**From:** [Webb, Robert L.](#) on behalf of [Planning Development Review Services](#)  
**To:** [Jared Winchester](#)  
**Cc:** [Rodenbeck, Jay B.](#)  
**Subject:** RE: NM United - Minor Amendment application for signage  
**Date:** Friday, June 3, 2022 12:09:08 PM  
**Attachments:** [image003.png](#)  
[image004.png](#)  
[image005.png](#)

Please see attached Minor Amendment application for landmark premise signage to be constructed at the NM United Training Center at Mesa del Sol.  
This is a follow-up to the fast-trax building permit BP-2022-17768

AS-103

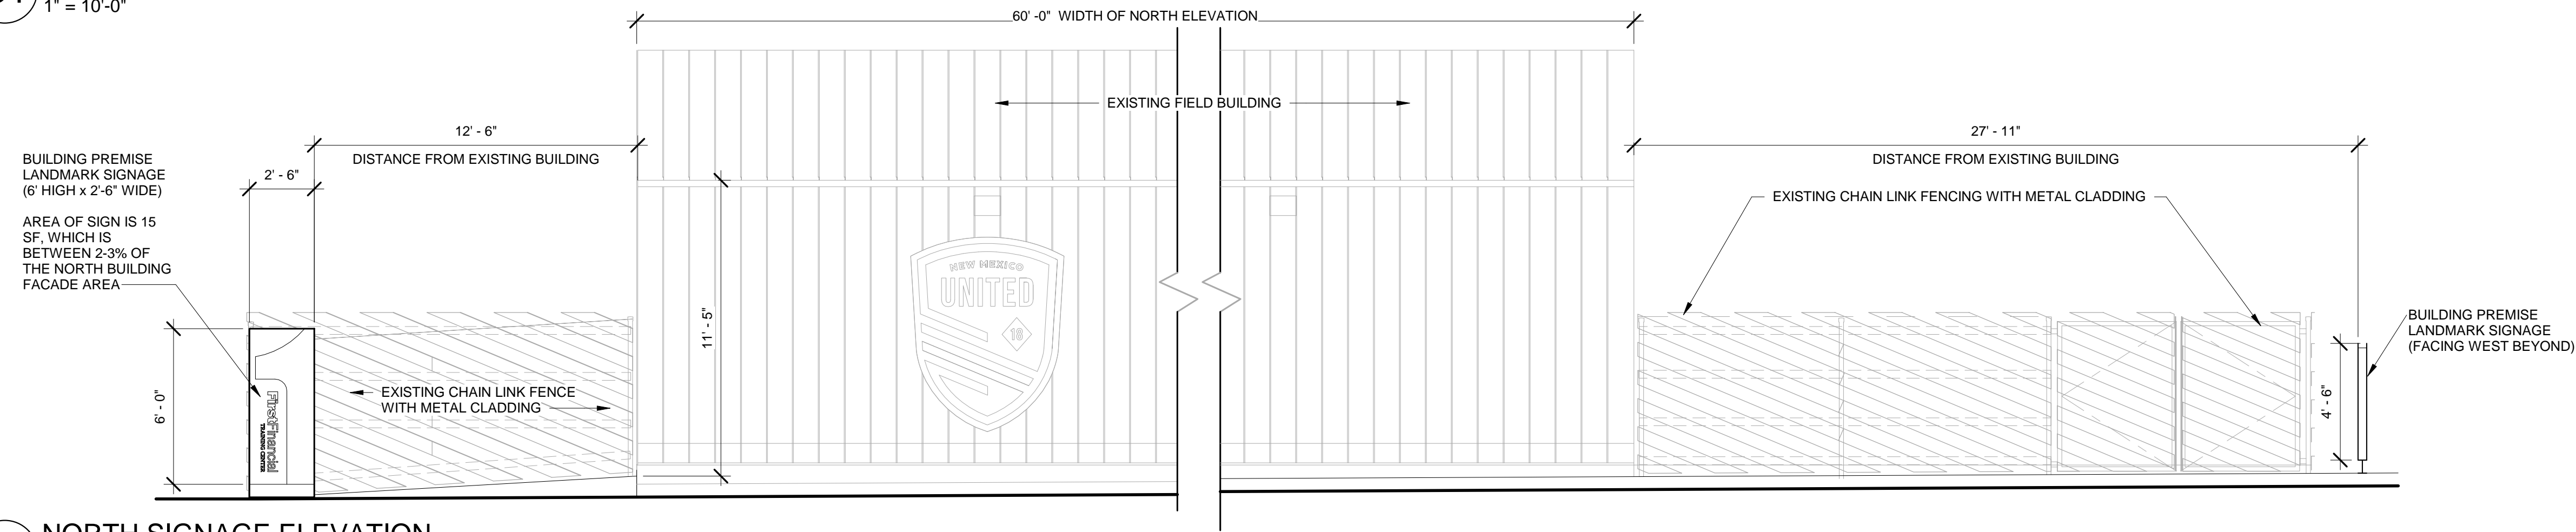
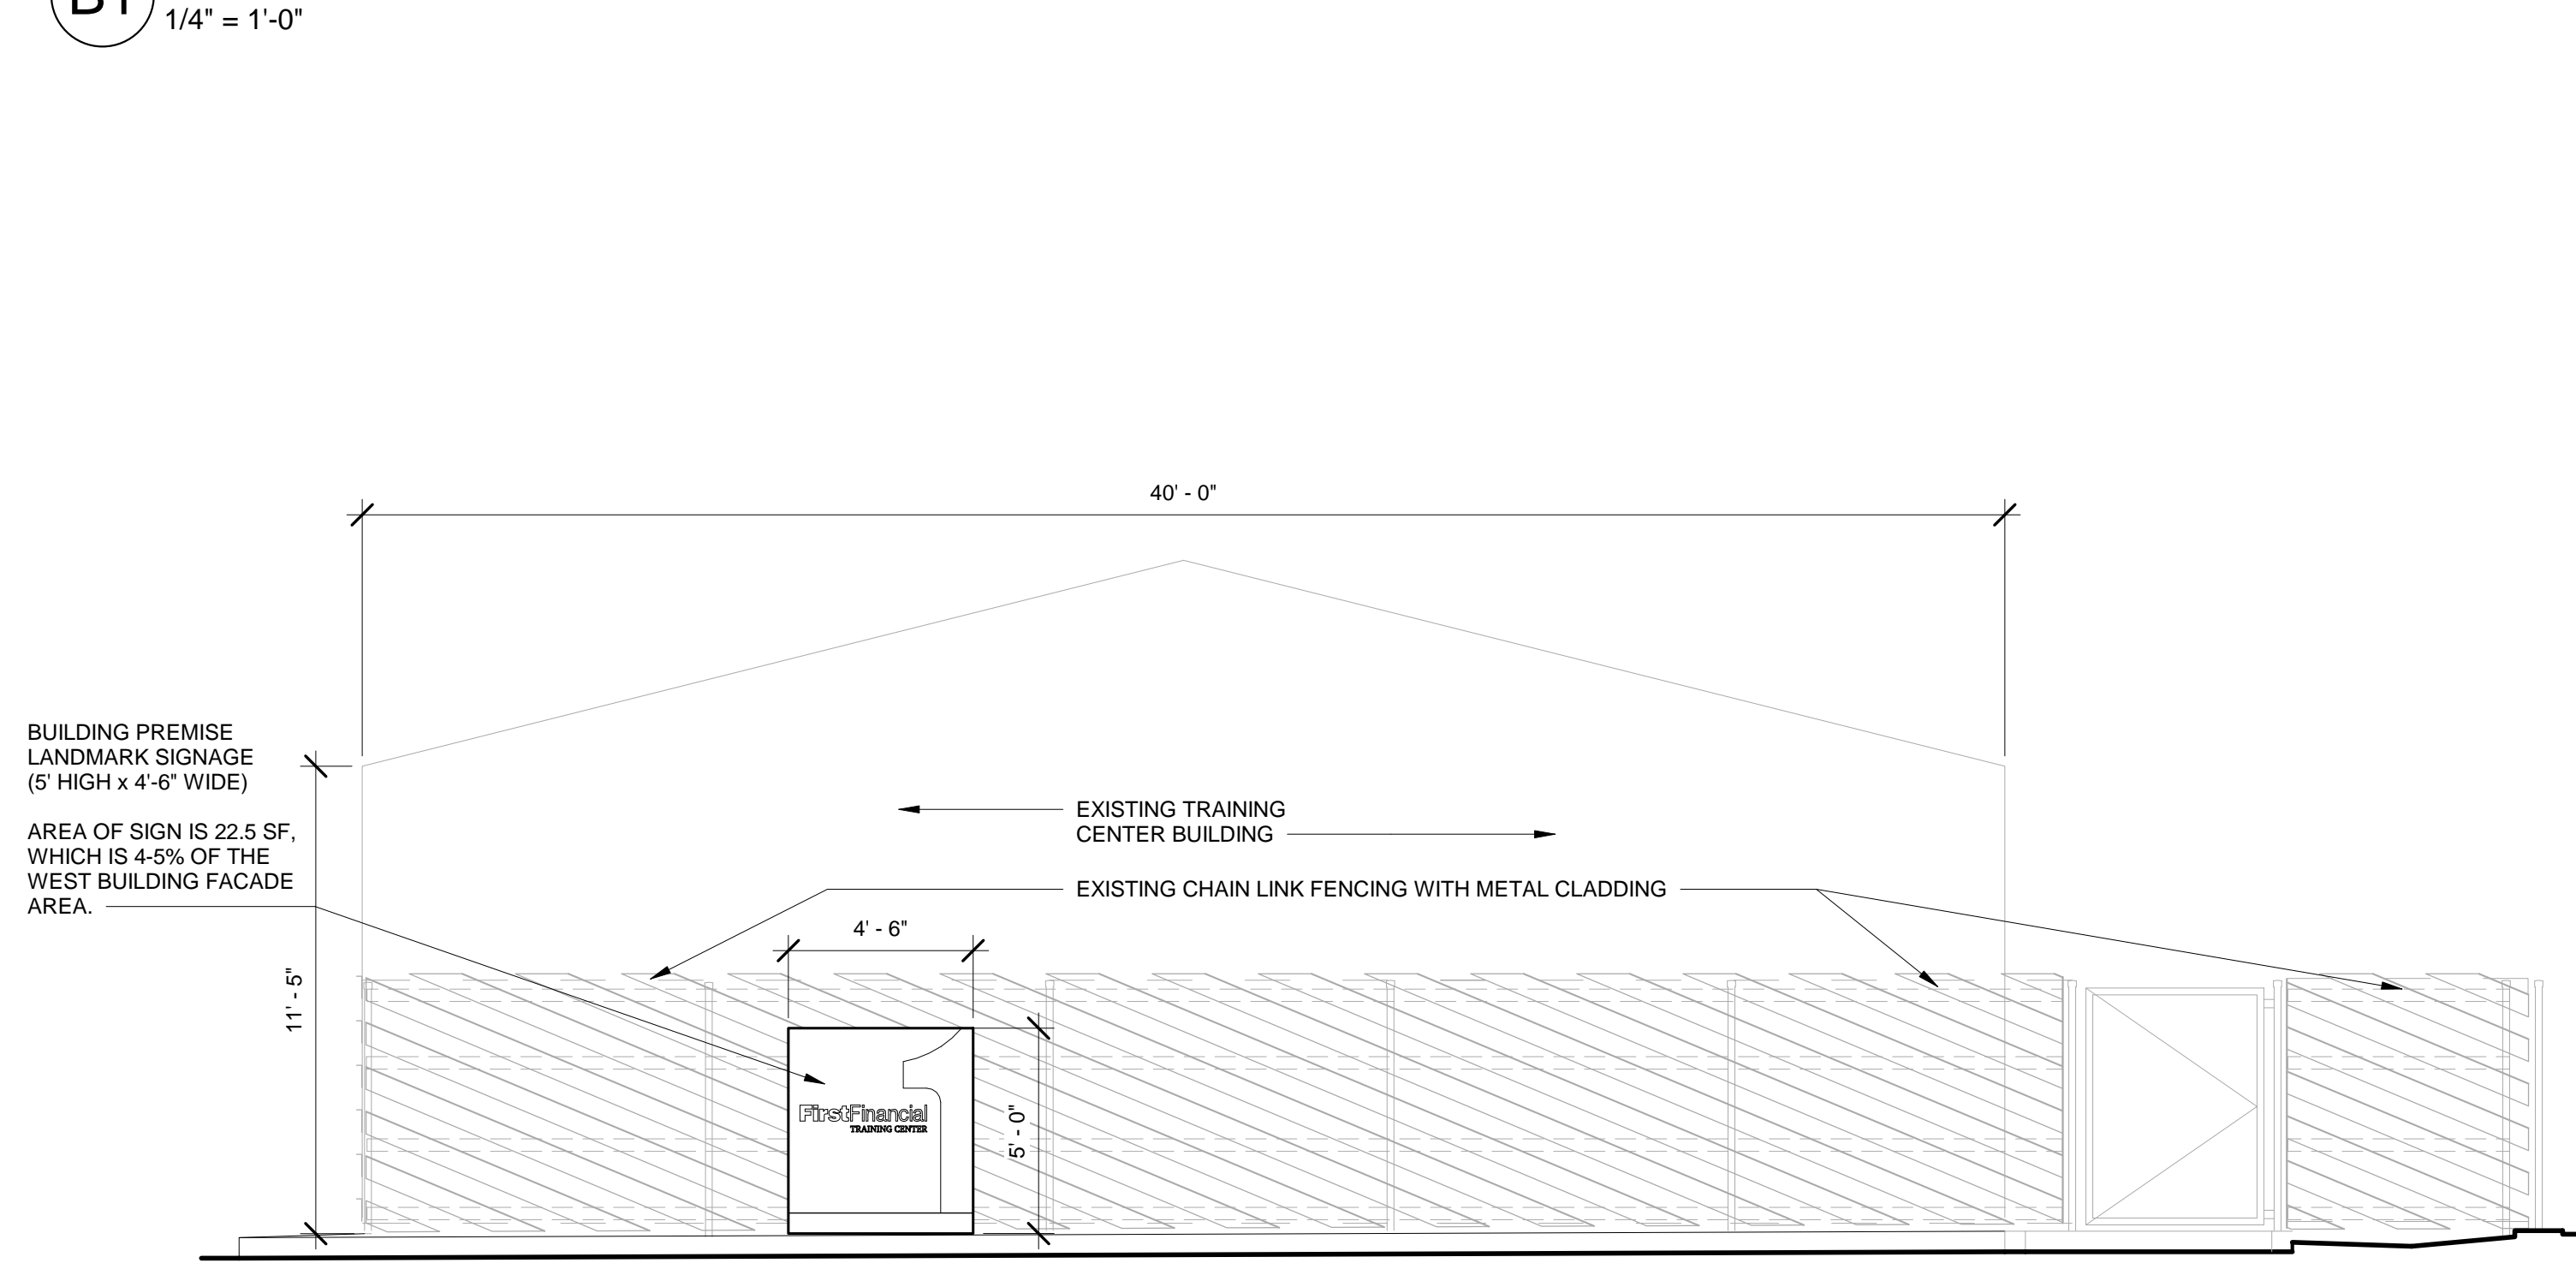
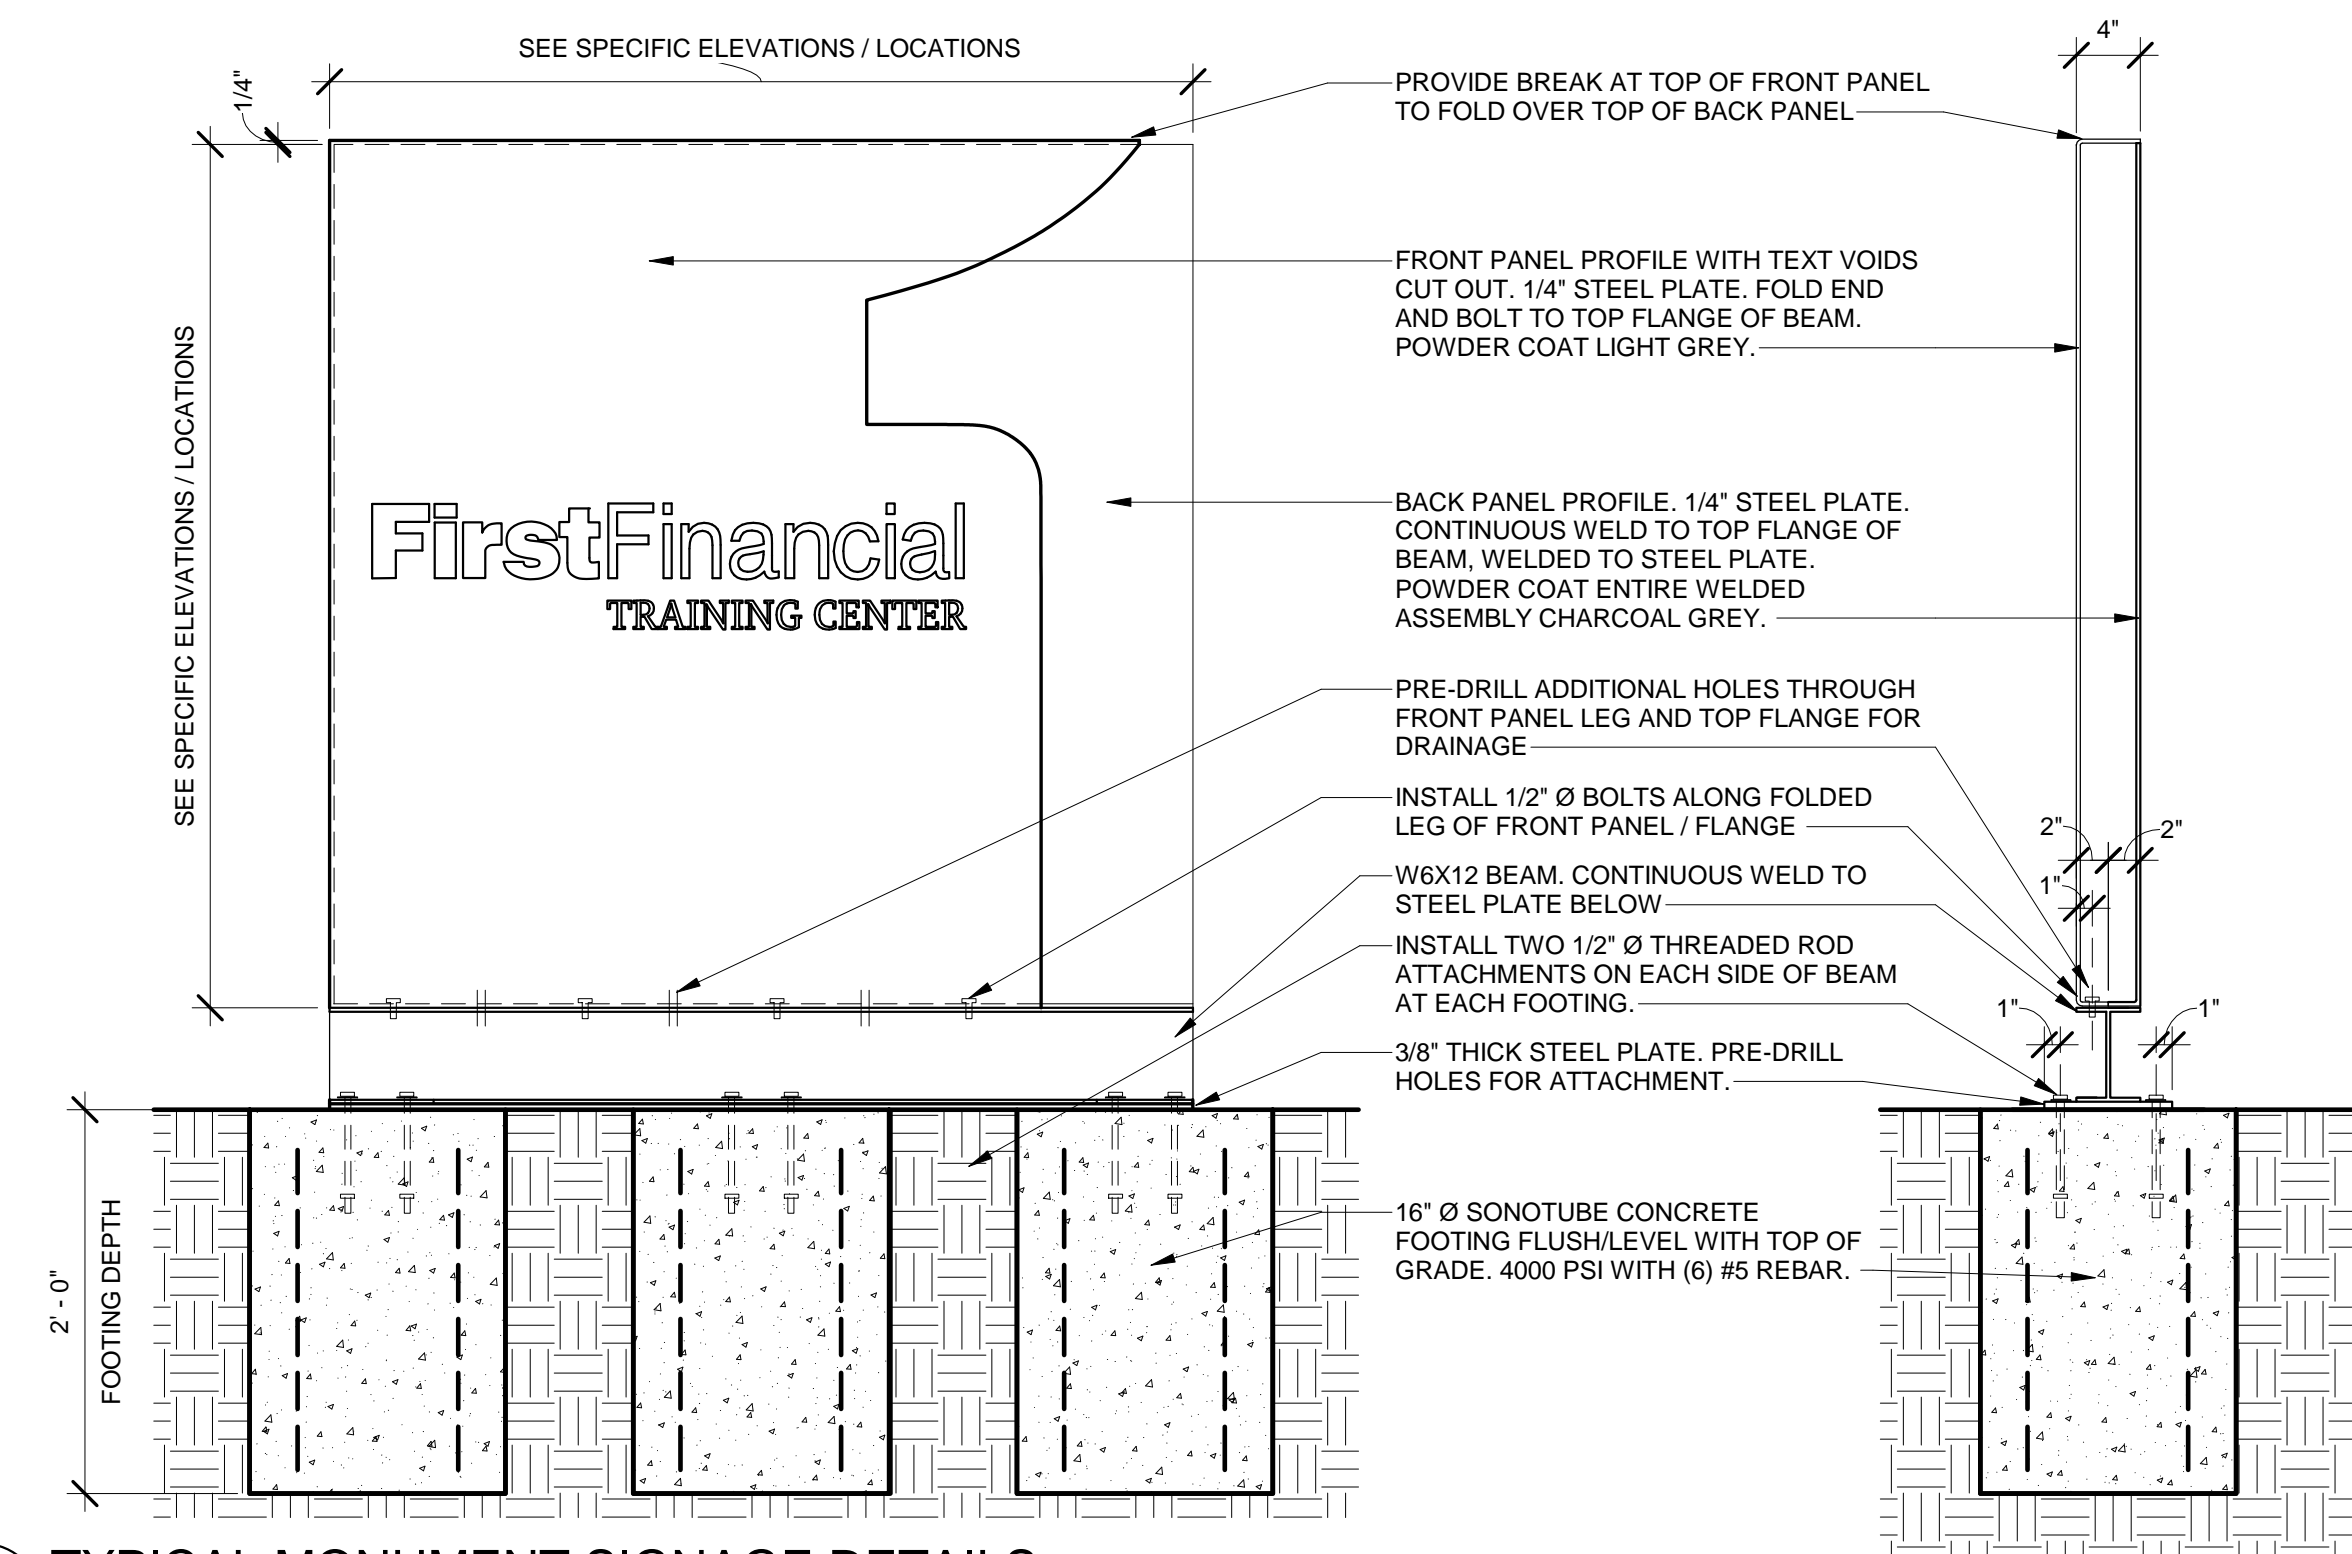
Needed to confirm the type of sign. The description and the illustration don't seem to match up.  
Is this a fairly standard wall/building sign that is attached to the new building and non-illuminated?

Or is this a separate free-standing sign structure next to the building?

-Please provide the dimensions of each wall façade where signage will be placed. Include both the façade percentage of each sign and the SqFt of each sign.

-If separate, we will also need measurement from building and property line to the new signs.

Along with a height measurement of each sign. Include elevations.

Does signage affect any existing driveways, access, sidewalks, trails, etc.?

*5-12(E)(3) Clearance 5-12(E)(3)(a) Any part of a sign extending over a public right-of-way, private way, or private walkway shall have a minimum vertical clearance of 8 feet above any sidewalk or walkway and a minimum vertical clearance of 12 feet above any vehicle driving surface, unless it is a sign allowed by Subsection 14-16-5-12(F)(4)(b) (Portable Signs), 14-16-5-12(I) (Construction Period Sign), or 14-16-5-12(K) (Transit Shelter Signs).*
